1. ELEVATIONS

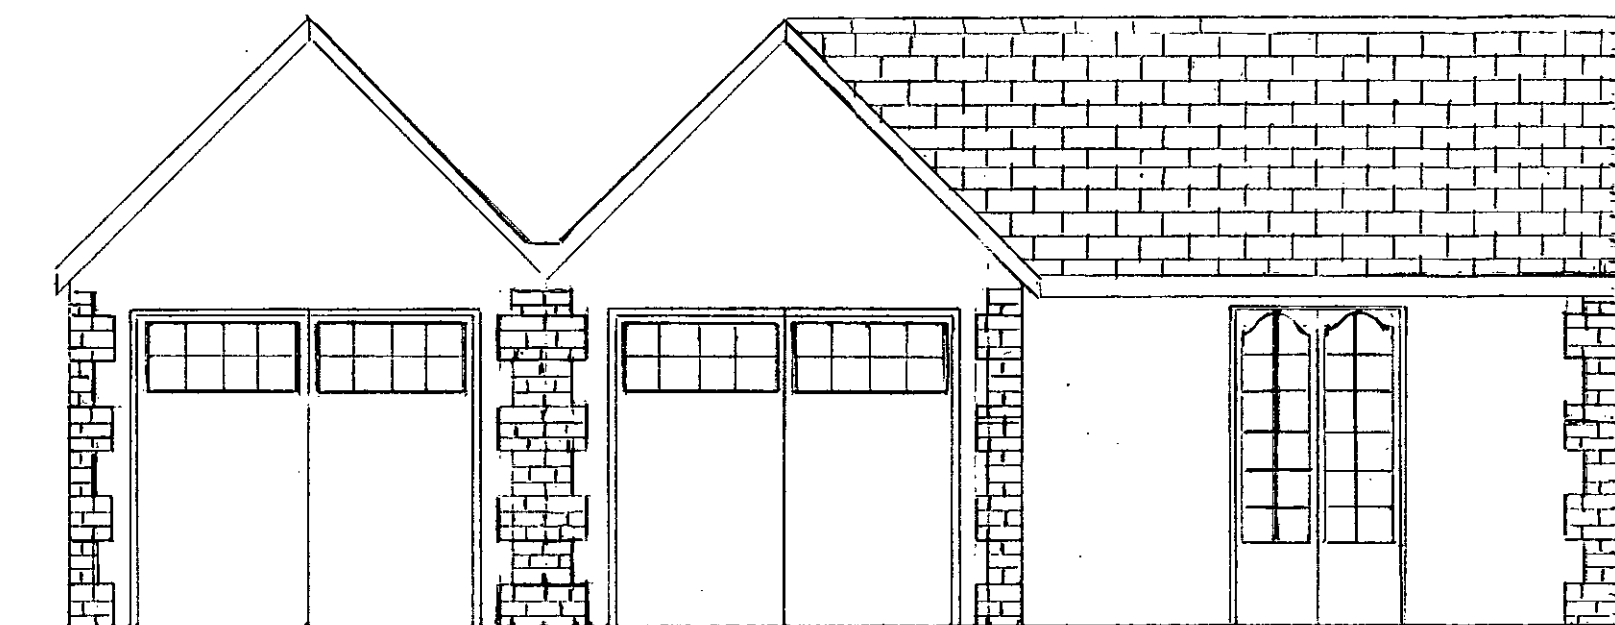
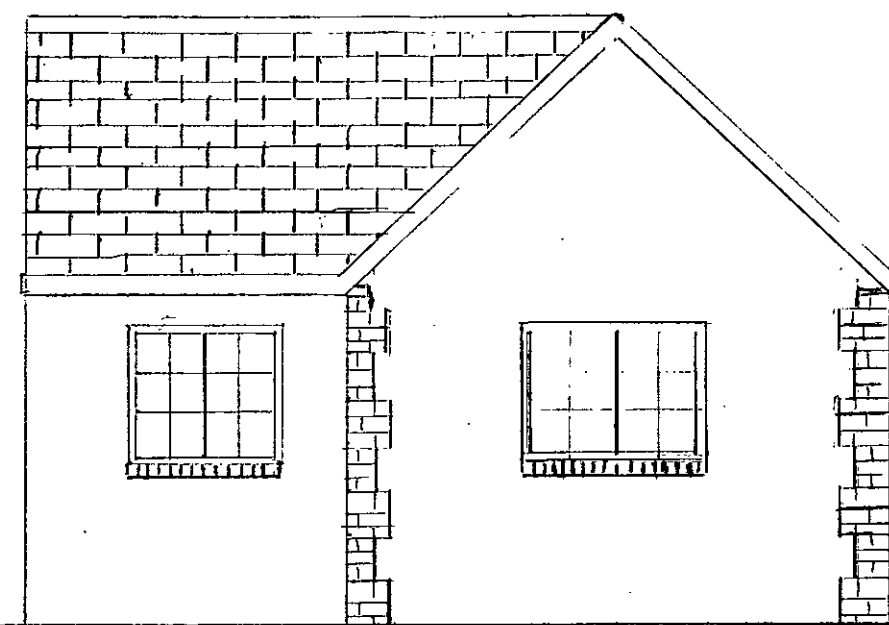
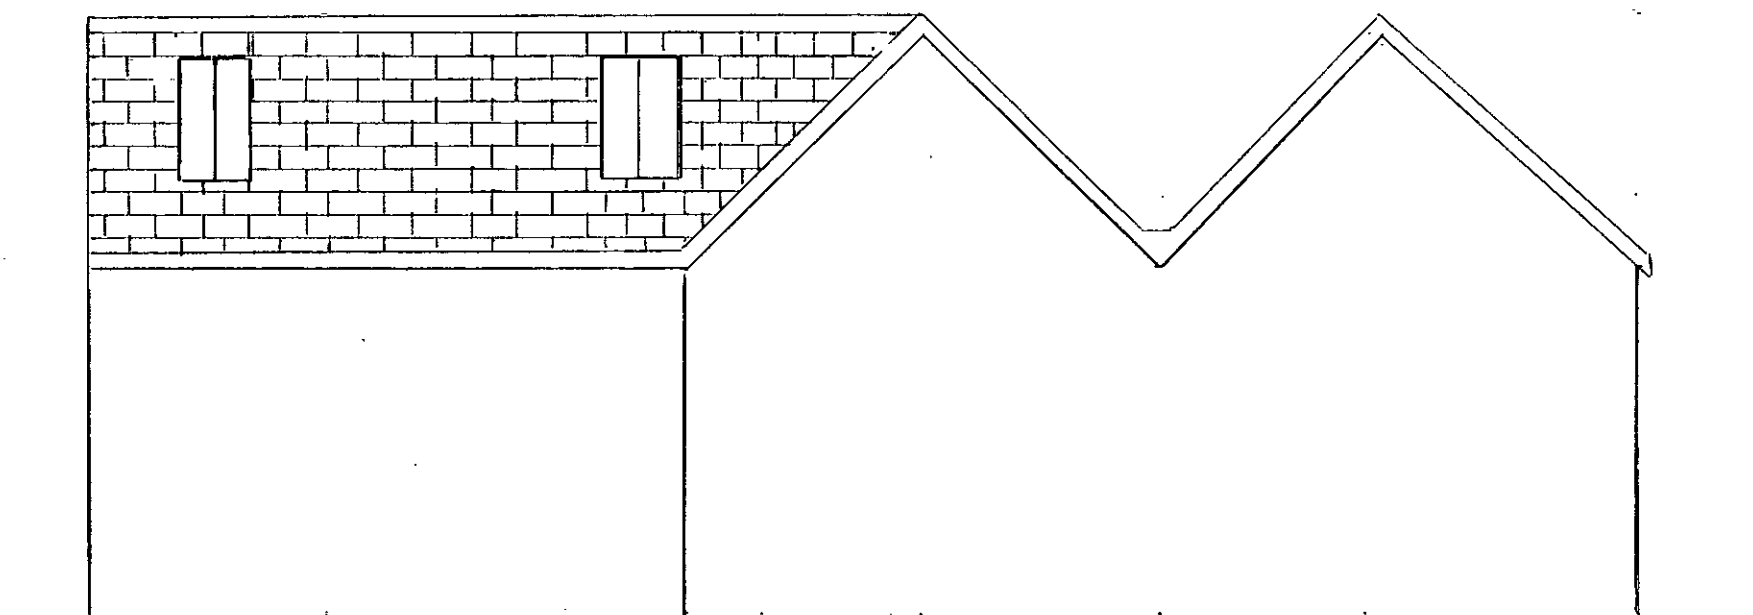
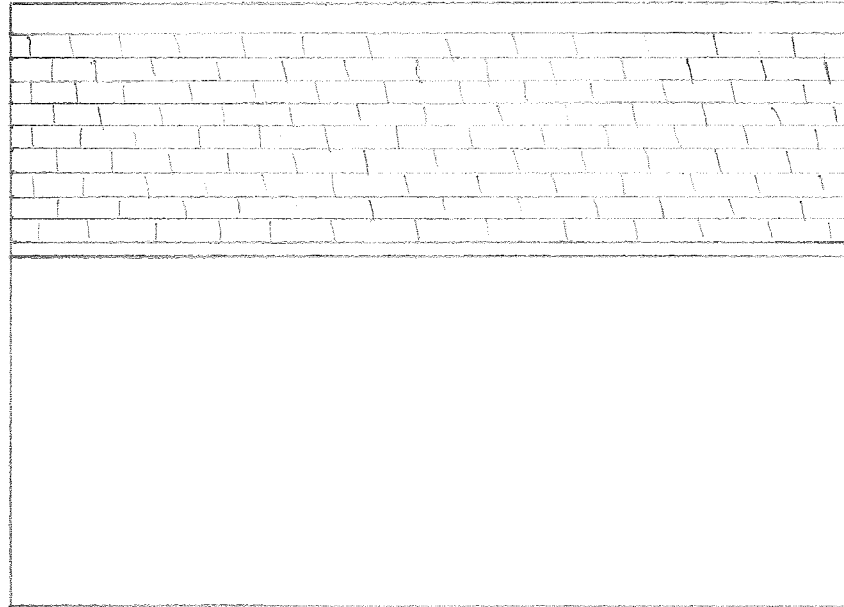
The existing garage is of masonry construction, and reflects the character of the existing dwelling. It is small scale, and as a consequence subservient to the main property.

It is considered that there is potential to extend the garage structure to provide for the required accommodation. However, any new works should closely reflect the existing structure in terms of scale and appearance.

The building should still read as a standalone garage outbuilding (more akin to option A), so that it reads as a subservient standalone structure, and maintains the appearance of the existing garage structure."
